AW/43/18/OUT – 261 Aldwick Road, Aldwick, PO21 3QU

We oppose this Application for development at 261 Aldwick Road, Bognor Regis because it will have a serious and significant detrimental effect upon our way of life and other Residents who reside at the Malmayne Court Complex.

*proposed site plan*

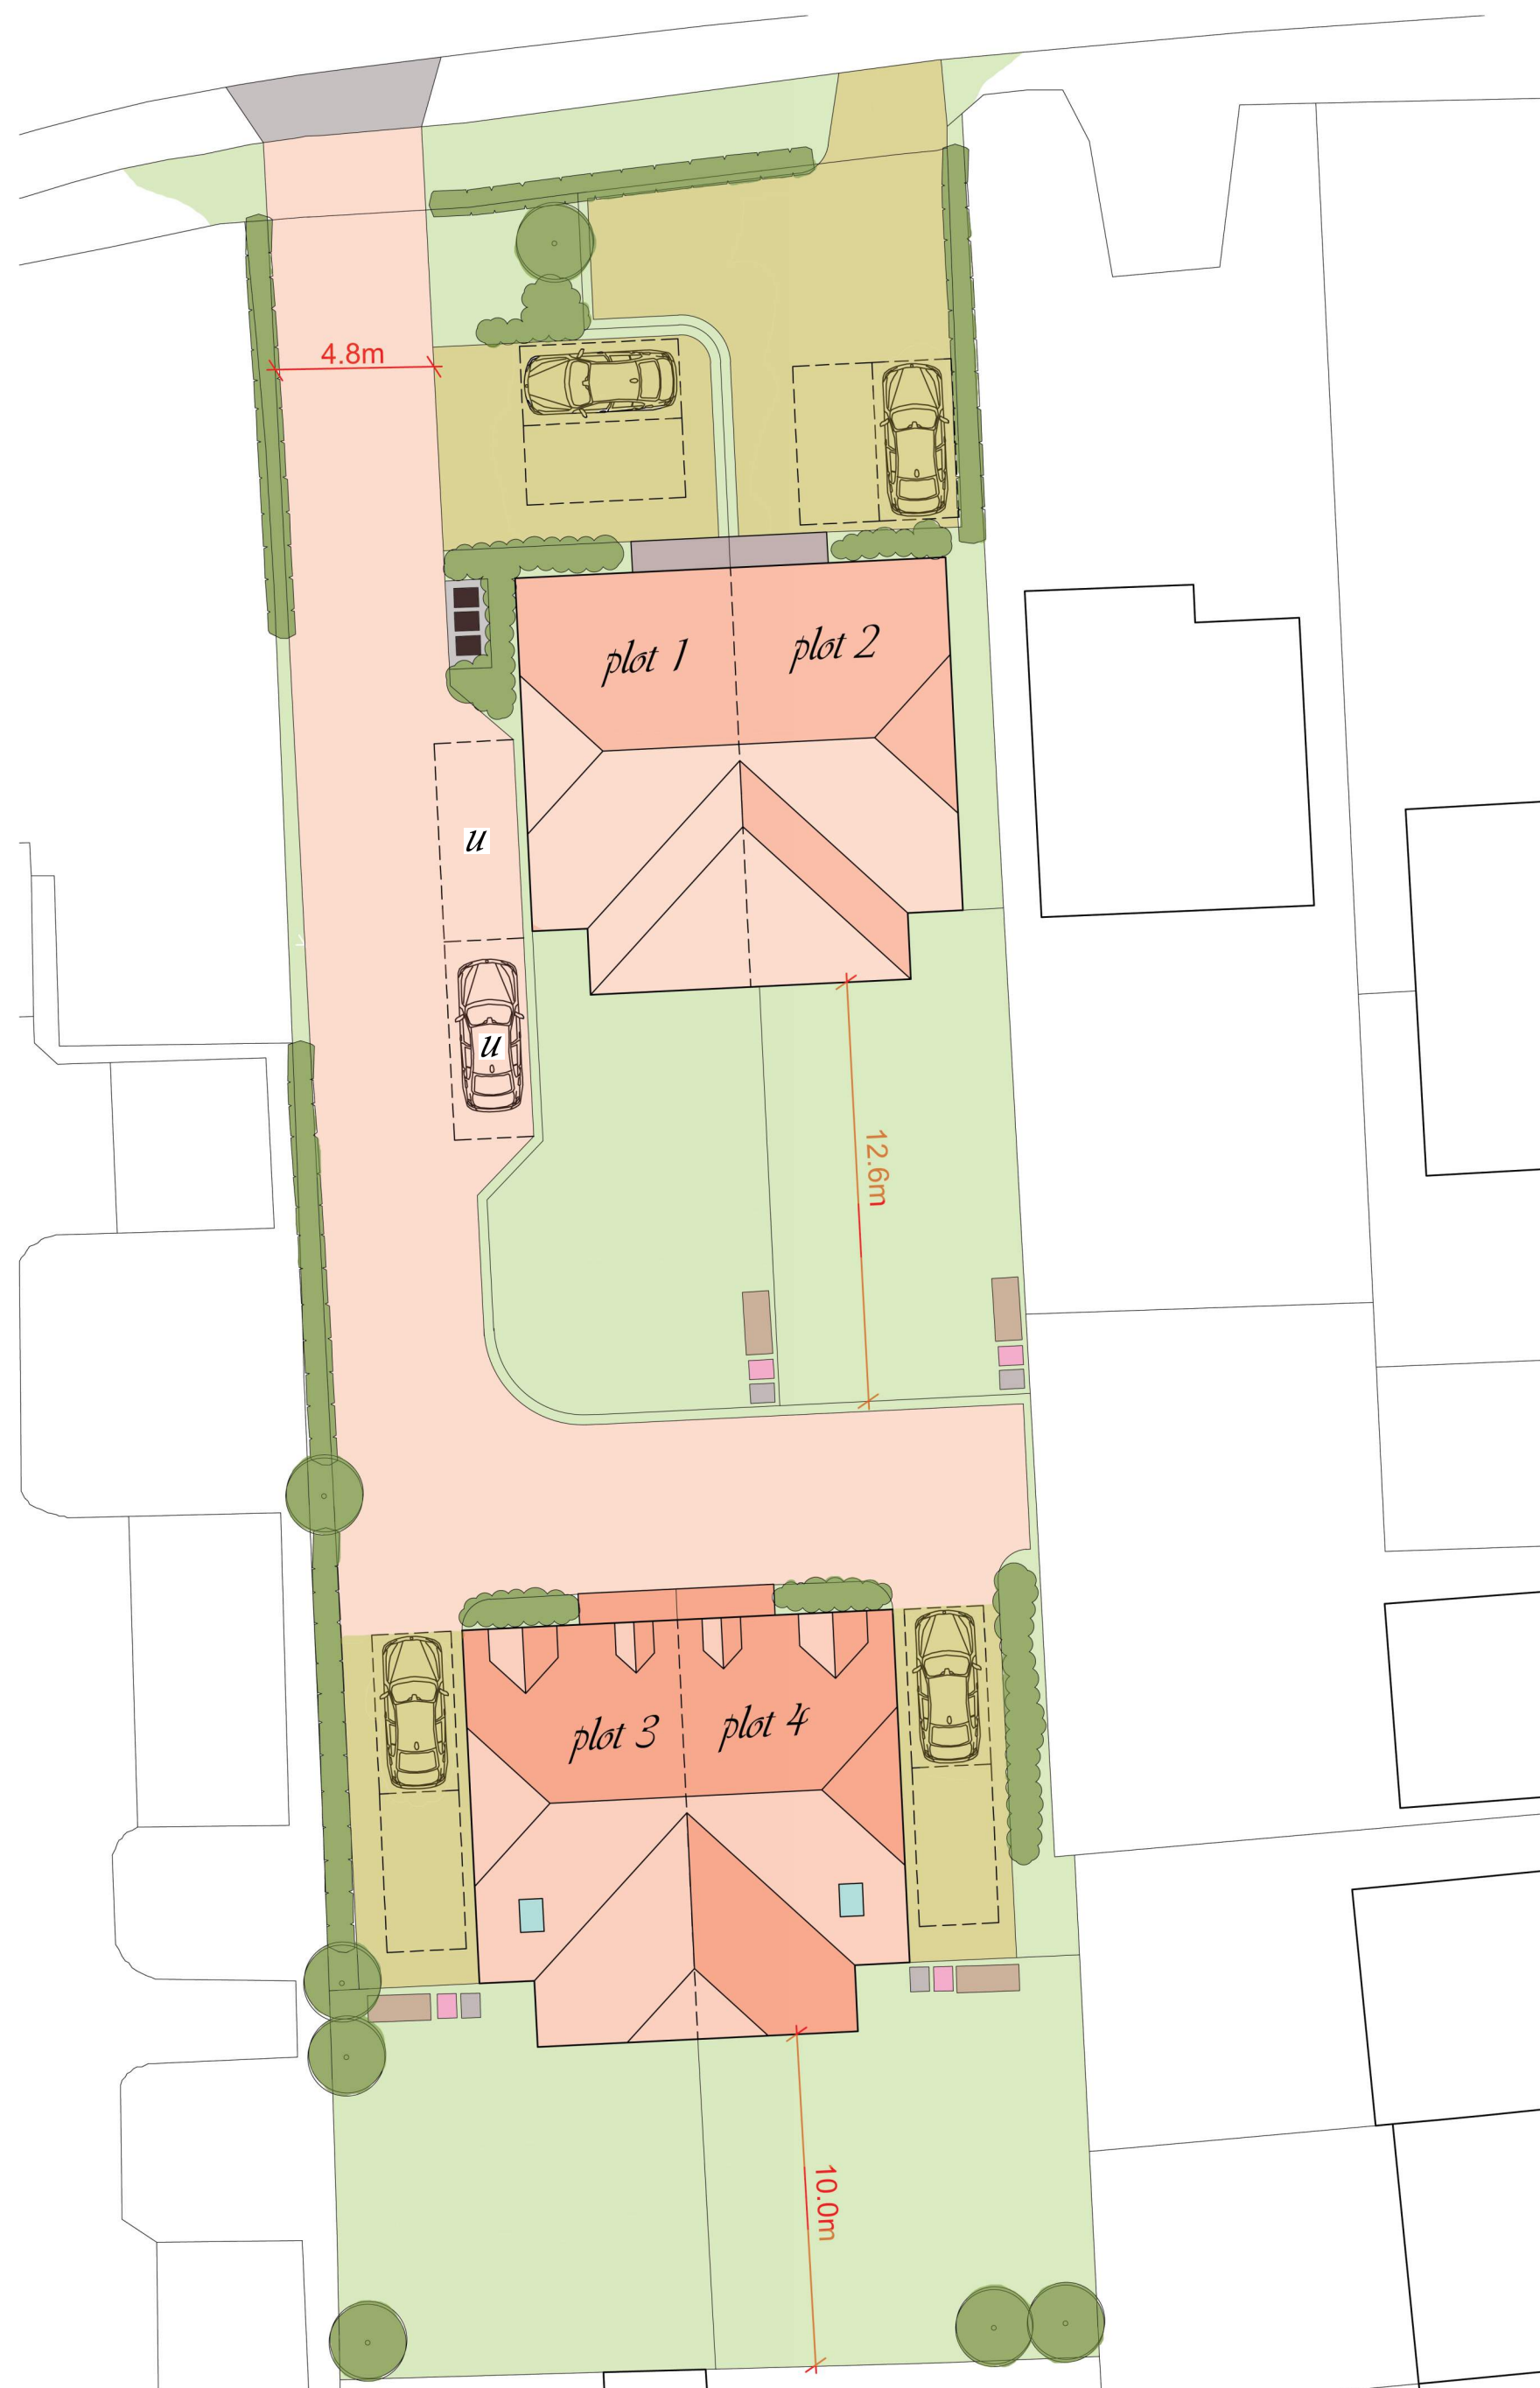
1. The siting of Plots 3 and 4 on the plan indicate that this building will be in direct line with our windows and due to the length of the proposed houses this will take away a pleasant view as it now stands. The plans submitted show quite clearly that it will be impossible to shield the proposed houses with trees or shrubs because there will just not be the room for them. The fact is that the proposed Plots 3 and 4 will fill an area which has always been an open space and enjoyed by not only us, but all the Residents at Malmayne Court.

4. Should the block referred to as Plots 3 and 4 have windows in the side facing Malmayne Court this would affect our privacy because they would look straight into our living room and bedroom windows.
